Please upload the email below which is a further consultation response from **ADC Drainage Engineers** to discharge of condition application **LU/90/20/DOC** – Hampton Park.

Paul Cann
Principal Engineer (Drainage)

Flow Control Chamber HB1

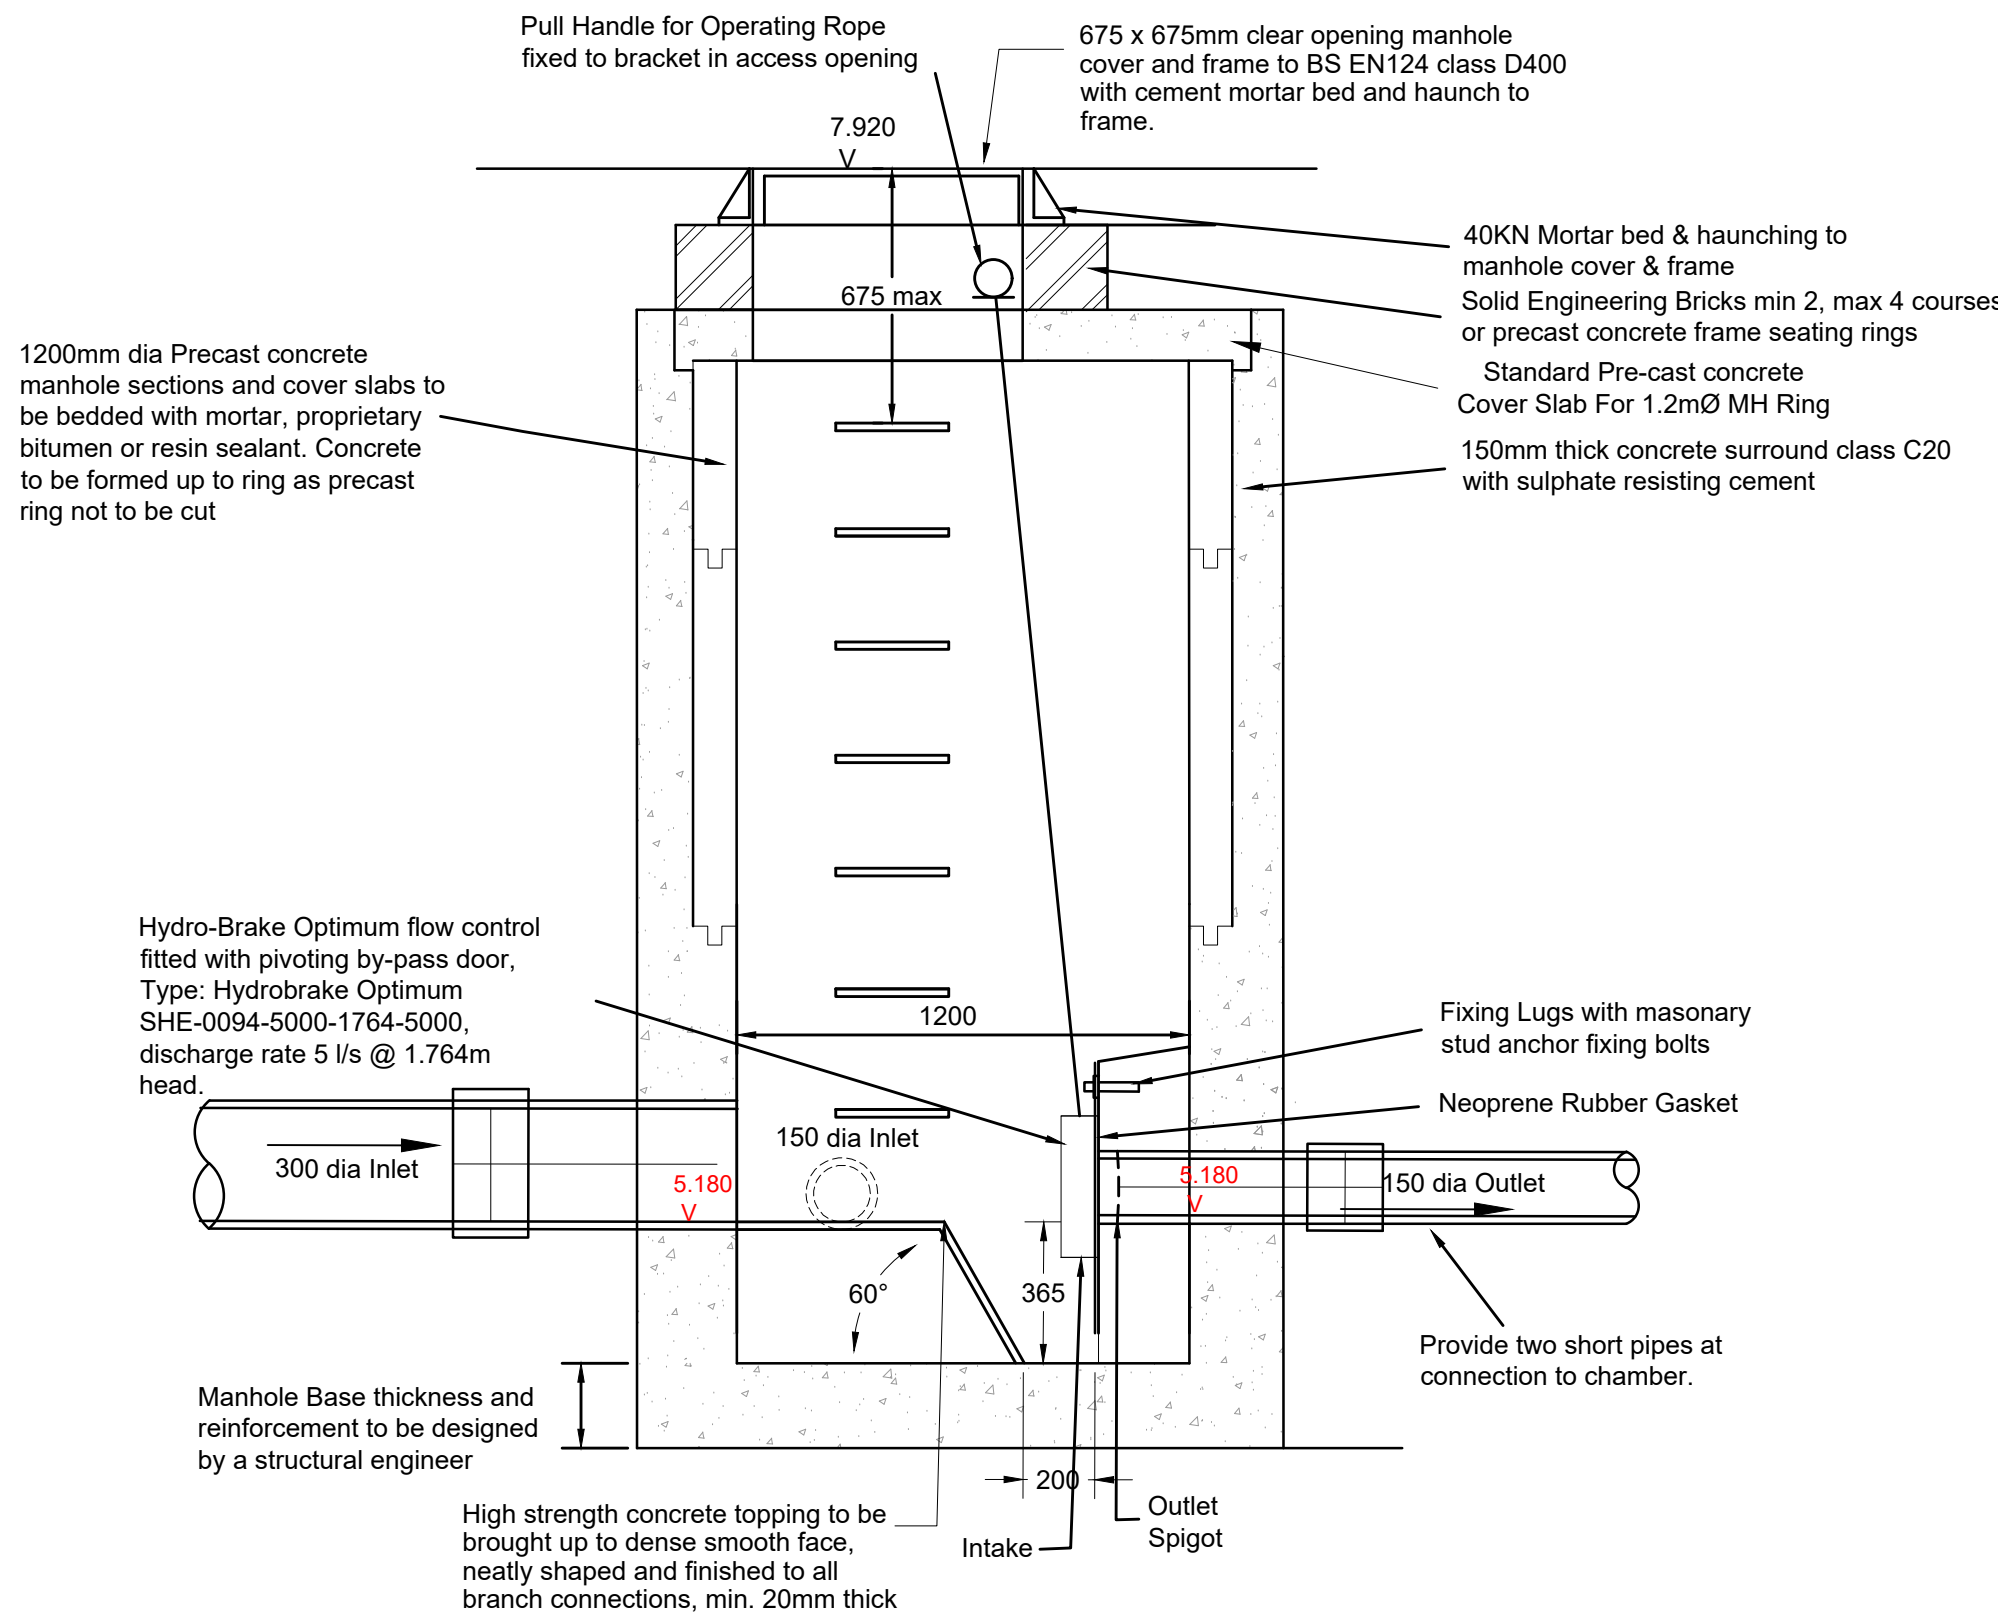
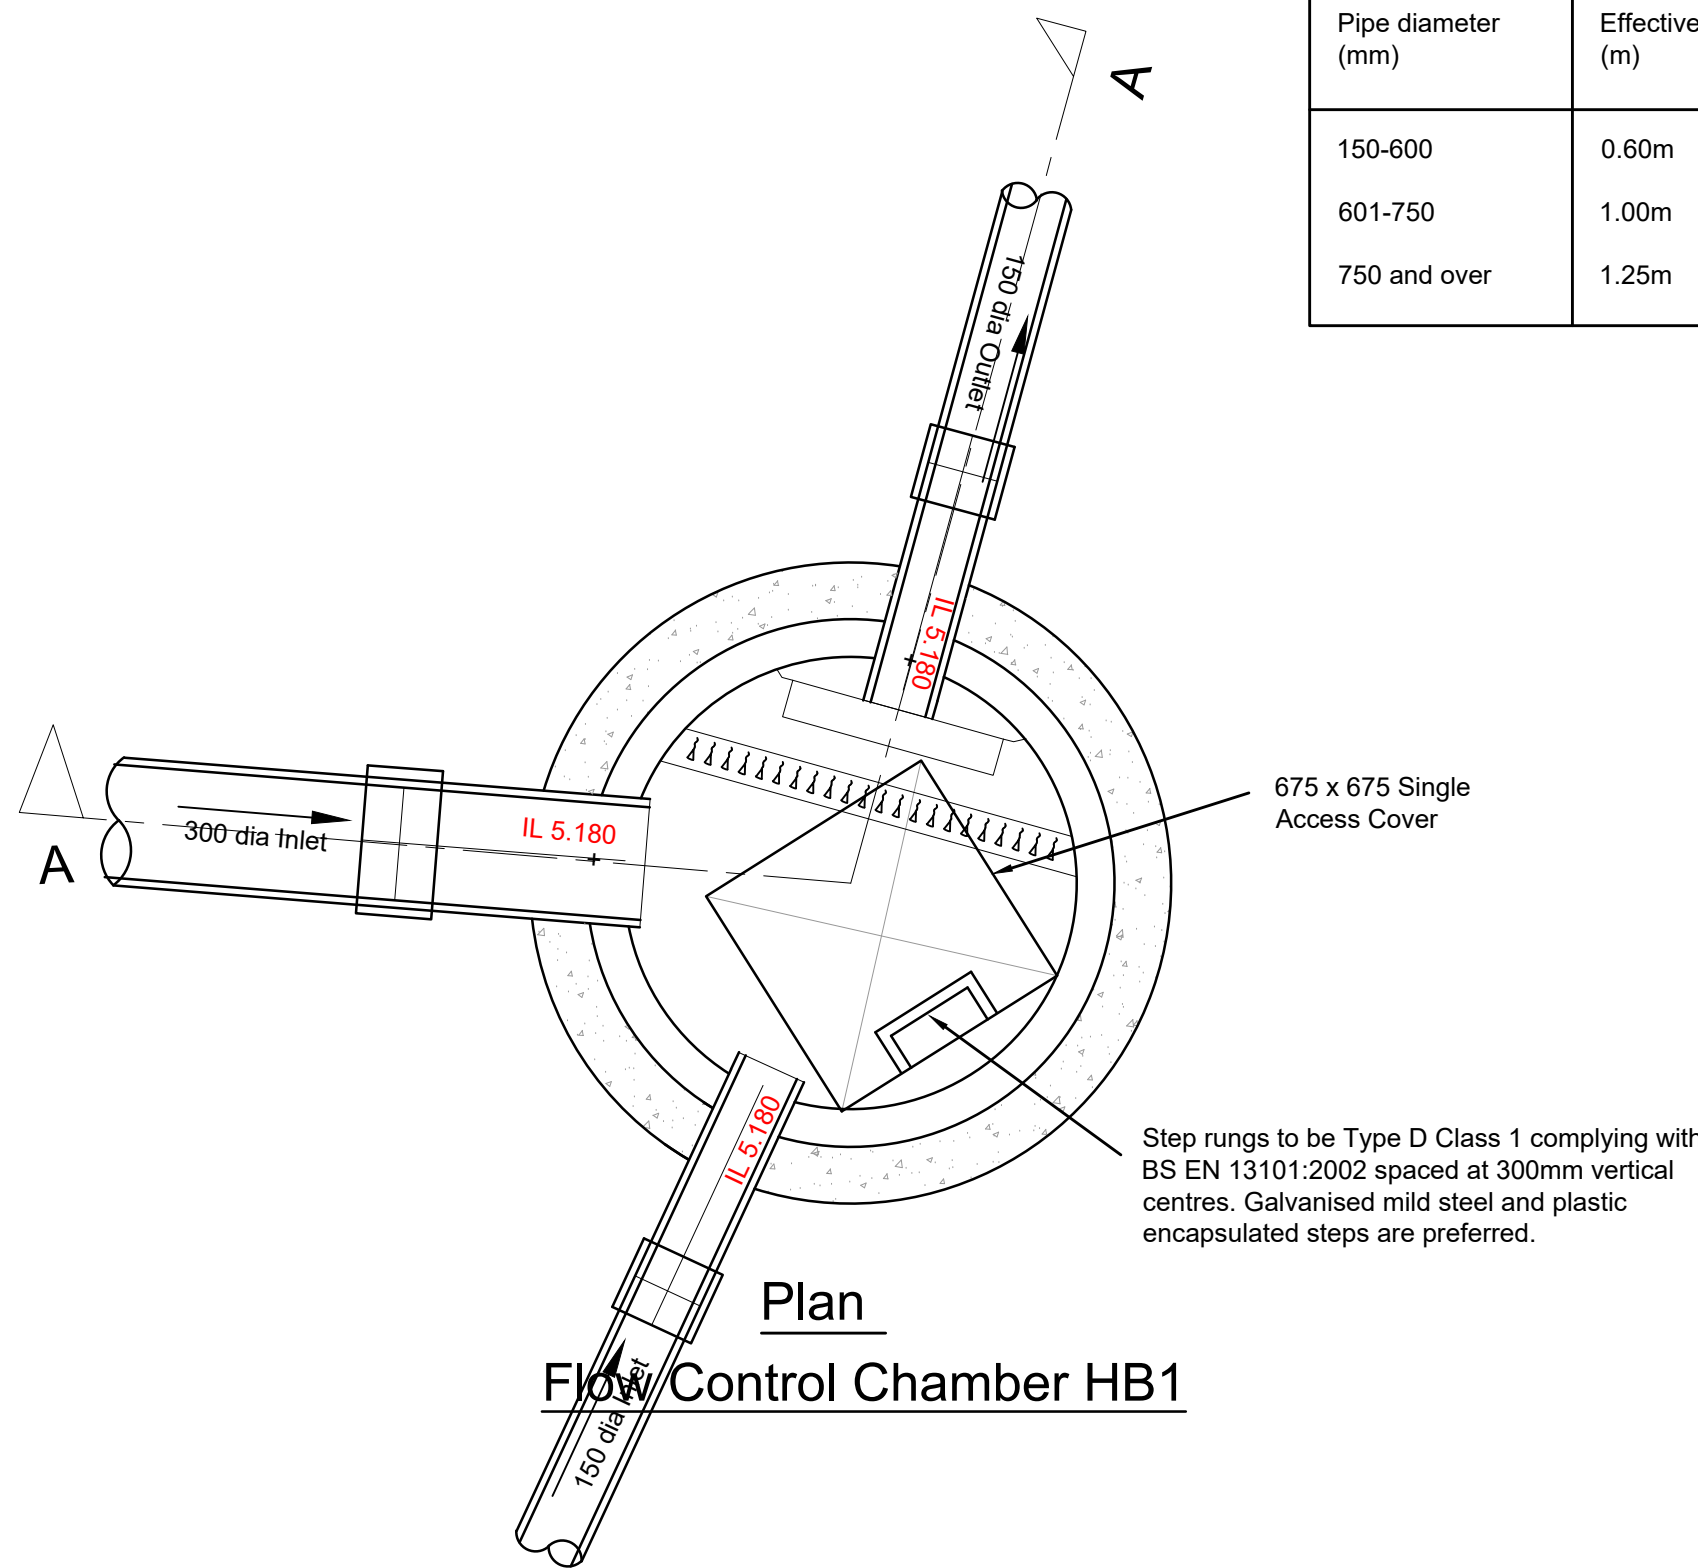
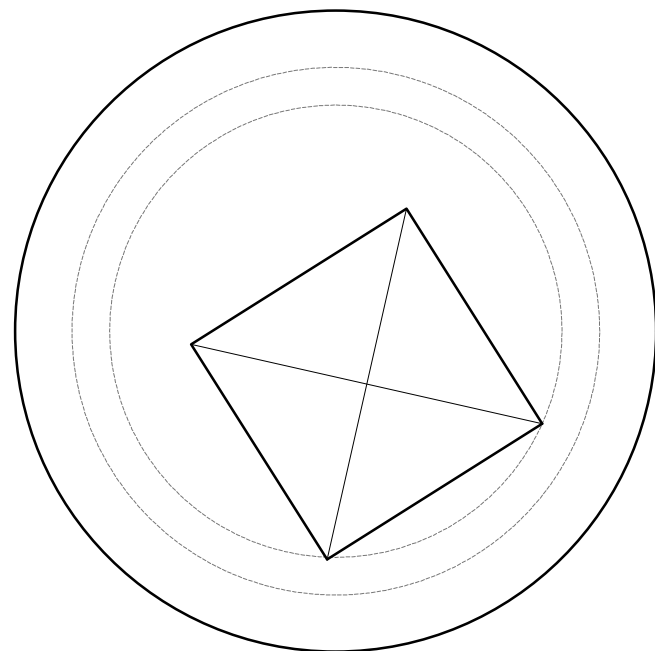
3. Provide channel drain construction details/spec.
4. Hydrobrake chamber HB01 construction detail – connect incoming 150mm connection from permeable paving at soffit to soffit level with 300mm pipe inlet.

6. Both hydrobrake chambers – show base thickness/reinforcement details.
7. Existing manhole SW03A – just upstream of SWA2_01 – what is its purpose? Invert level is lower than the downstream manhole. Please clarify if it is required and adjust as necessary.
